DRB Project Number: 2019-003169 Hearing Date: 10-30-2024  
Project: Sage Road – Tract 401, Unit 3,  
Atrisco Grant Agenda Item No: 8

**SD-2024-00151 –FINAL PLAT**

**Project Name:** Sage Park Subdivision

**Requests:** Final Plat; subdivide 1 tract into 4 tracts and 77 lots

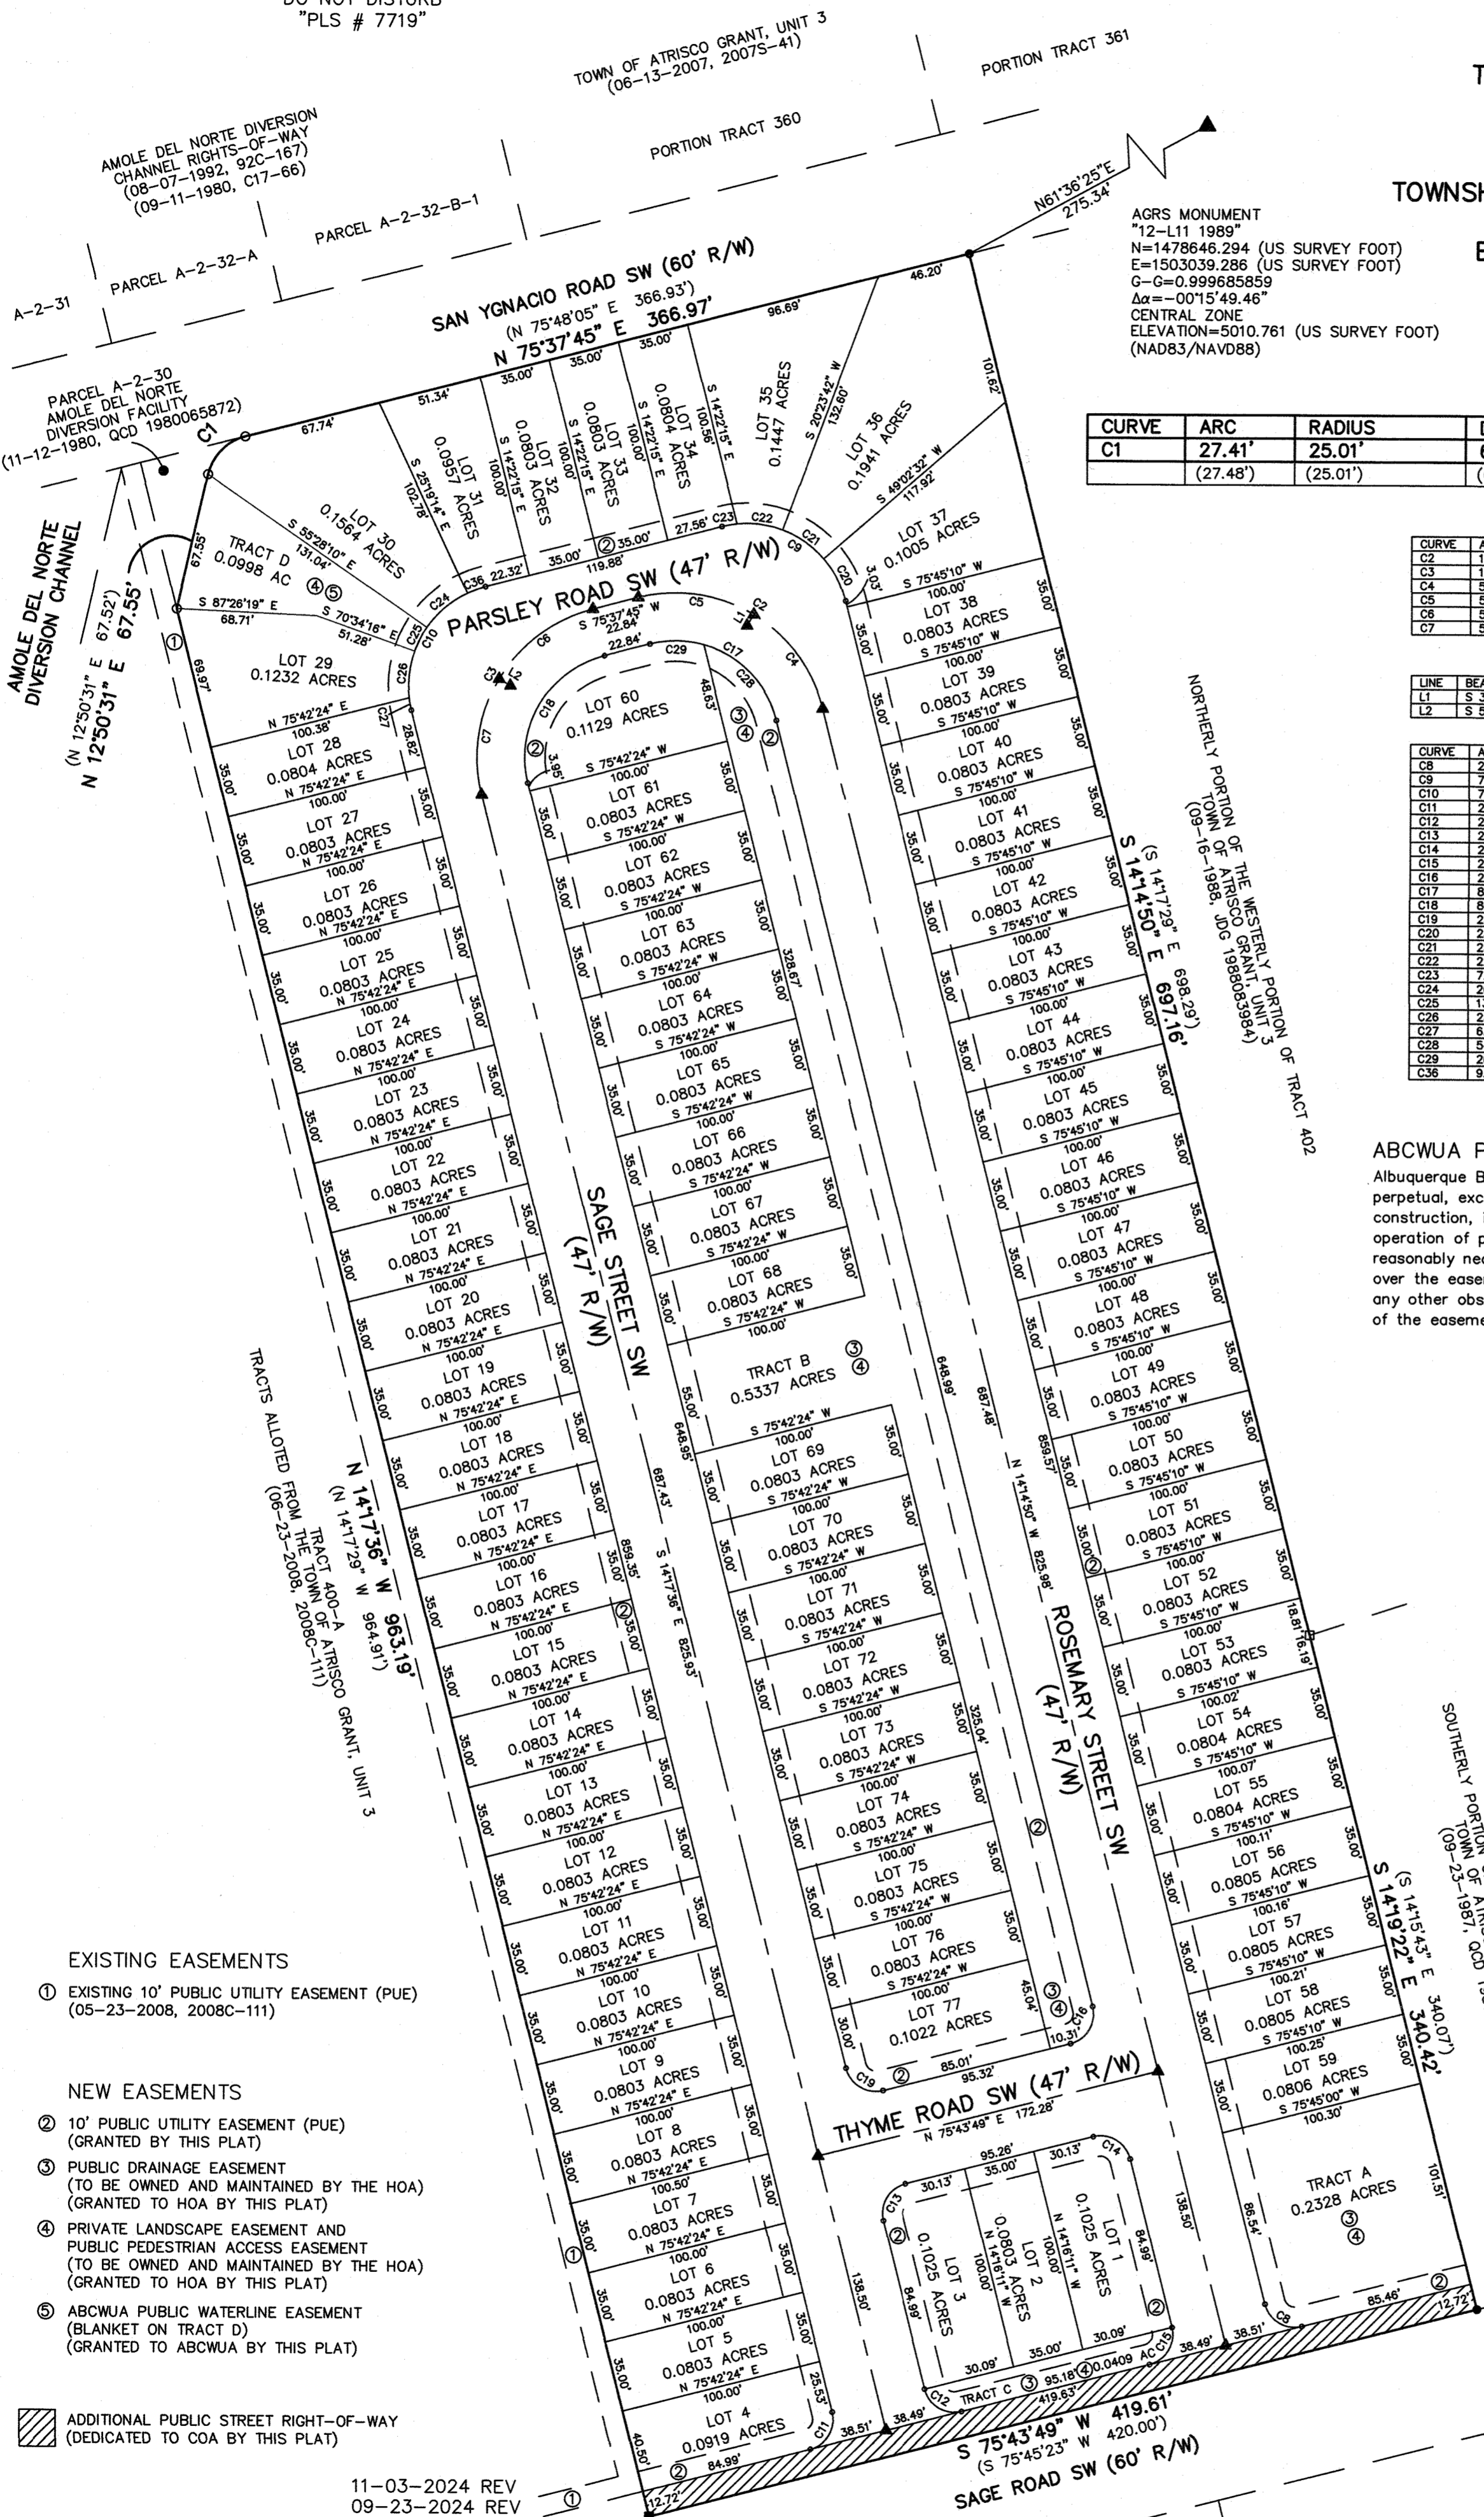
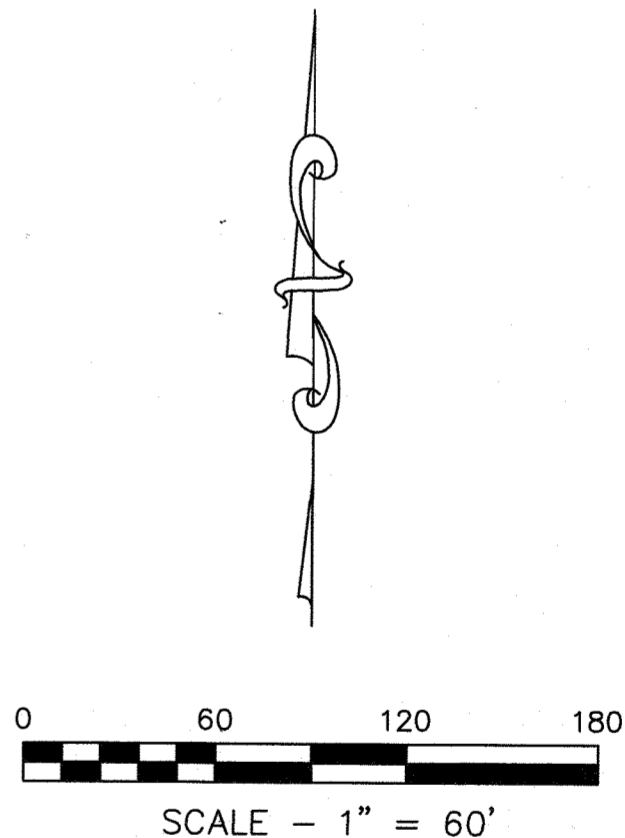
- Condition “D” in the Notice of Decision for the Preliminary Plat (PR-2019-003169 / SD-2023-00132) noted that “the easement be updated such that there is no drainage easement on Tract D.” However, a drainage easement is still labeled on Tract D. Compliance with this condition must be confirmed with ABCWUA.
- The Application number must be corrected on the Plat.
- The AGIS DXF file approval must be submitted.
- The date of the DHO approval shall be recorded on the Plat.
- After DHO approval and final sign off, a recorded copy of the plat must be sent to Jay Rodenbeck at [jrodenbeck@cabq.gov](mailto:jrodenbeck@cabq.gov) and Angela Gomez at [agomez@cabq.gov](mailto:agomez@cabq.gov).

1. The plat provided calls out a 20 public waterline easement. This either needs to be delineated or a blanket easement on the tract.
2. Please add the following note to the plat:
